Application by Gloucestershire County Council for M5 Junction 10 Improvement Scheme
The Examining Authority's written questions and requests for information (ExQ1)
Issued on 9 July 2024

INSET 1A
@SCALE 1:2500

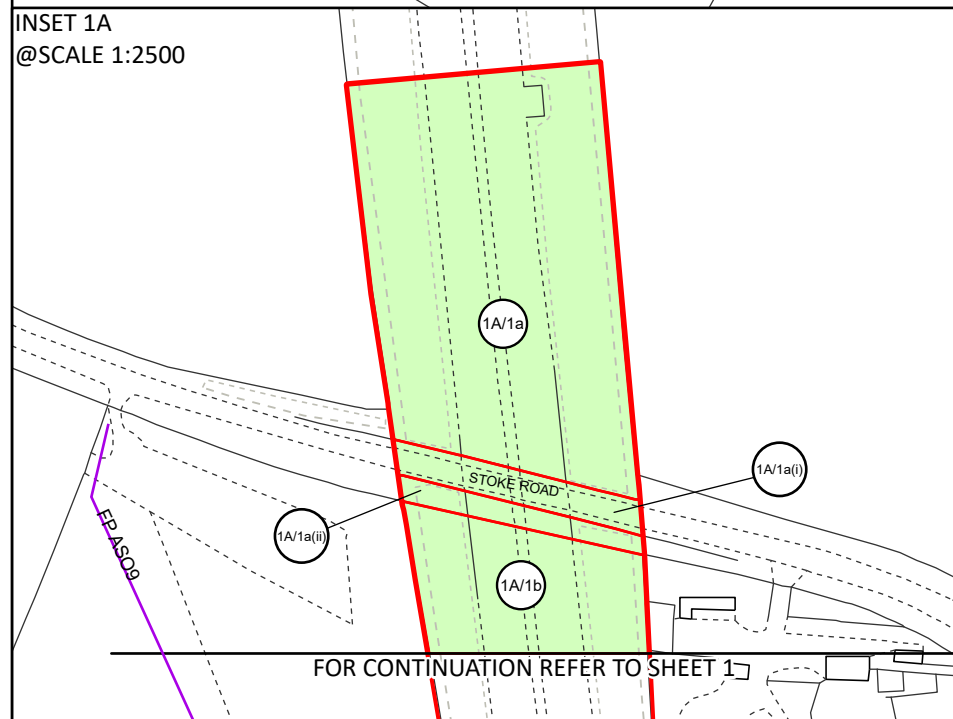
Q1.05	The Applicant	<p>Land Plans [REP1-002]</p> <p>The Inset panel suggests plot 3/2a continues to the east, whereas the main plan appears to indicate it falls short of the eastern side of the inset, please clarify and correct the plan if appropriate.</p>
Q1.06	The Applicant	<p>Book of Reference Change Log</p> <p>The change log provided at D1 [REP1-040] has a number of instances where it states, "<i>No change to DCO- provided we previously consulted</i>".</p> <p>Please confirm that the appropriate consultation has been carried out.</p>
Q1.07	The Applicant	<p>Population and Human Health</p> <p>(i) Within [APP-072] summary tables 13-58 to 13-61 are provided, however the text does not entirely correspond, could the Applicant explain the apparent inconsistency, and if appropriate further clarify if the chapter correctly reports the more/less beneficial/adverse effects?</p> <p>(ii) 13.15.16 – 13.15.24 Geographic sub populations under the sub-heading for construction four moderate adverse impacts are identified but eight are listed, can the Applicant please clarify?</p>
